Our Ref: FG/73/19/NMA

Non-material amendment following the grant of reference FG/28/19/HH for patio doors to rear extension north elevation to be replaced with French doors and sidelights. Minor repositioning of window to extension West elevation.

33 Downview Avenue Ferring BN12 6QW

West Elevation

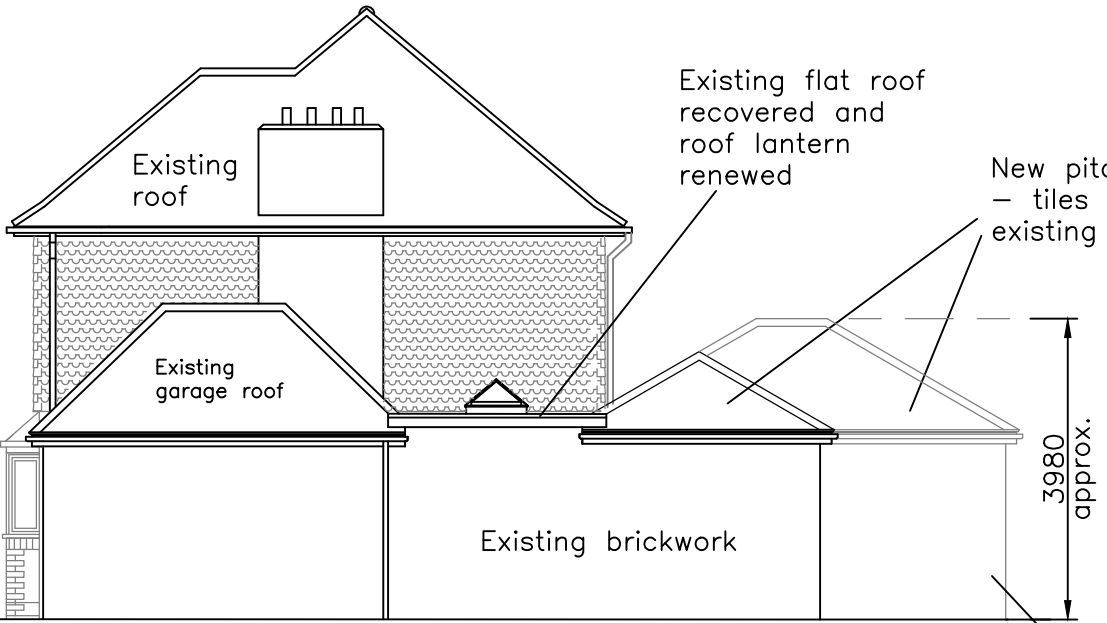
I refer to your recent application for a Non Material Minor Amendment. I note that you seek to replace the patio doors, with French doors and sidelights. Additionally, a repositioning of the window serving the extension, on the Western elevation.
